Our Ref: SL/25/11/L

Application for Listed Building Consent to attach a gate into an existing empty gateway from the road into the driveway. It will be set back 1 metre into the property with a side gate for pedestrian access. It will be a single 4 metre wide hardwood hook style gate with matching pedestrian gates. (1 fixed and 1 hinged). All in new oak with automatic sensor to open and shut. This application lies within the South Downs National Park Authority.

The Grange Church Hill Slindon

Photo of empty gateway where gate is proposed to hang. Looking out of driveway onto road.

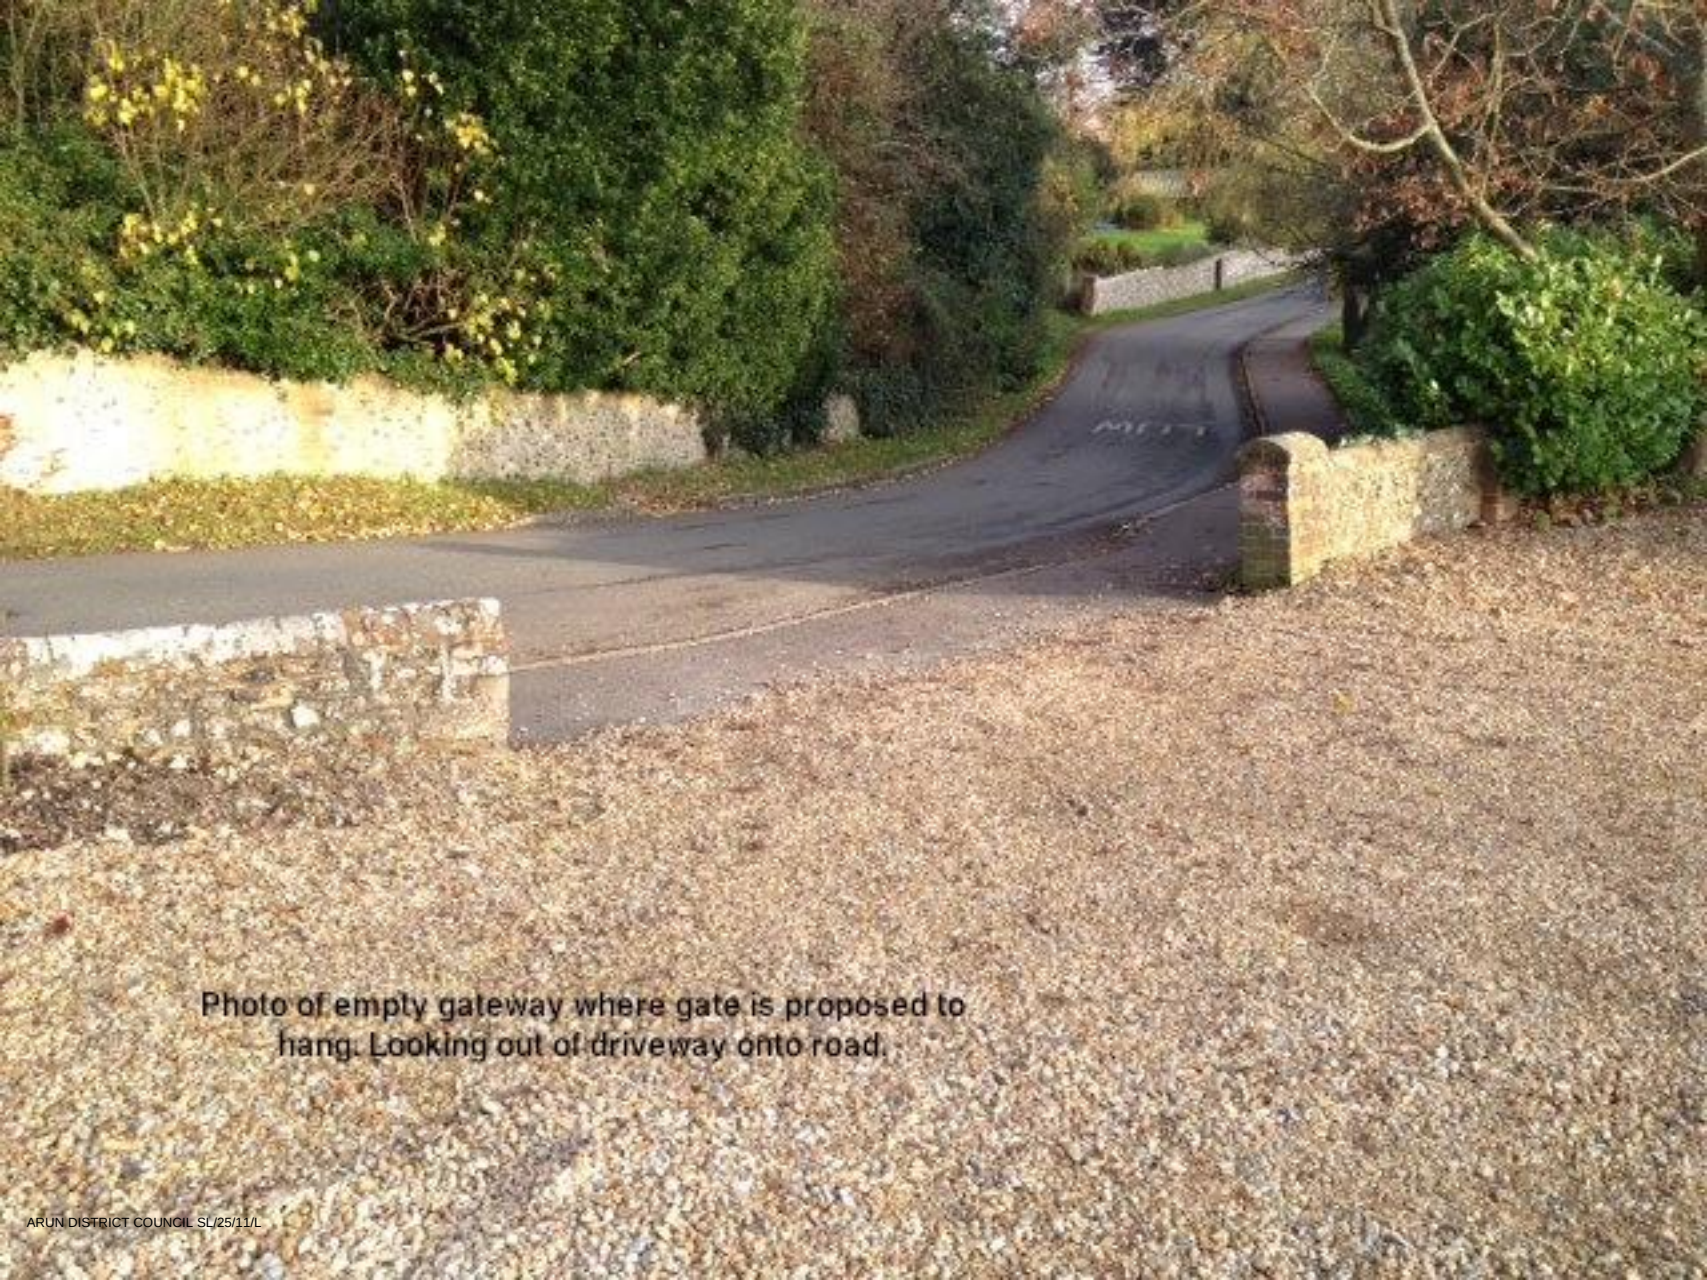
Slindon Parish Council considered this application at a meeting held on Monday 9th January 2012 and has no objection to the proposed wooden bar gate in the existing empty gateway provided that the new gate opens inwards and that the gateway is set back on to the property at a distance that is sufficient to prevent vehicles stopping on the highway.
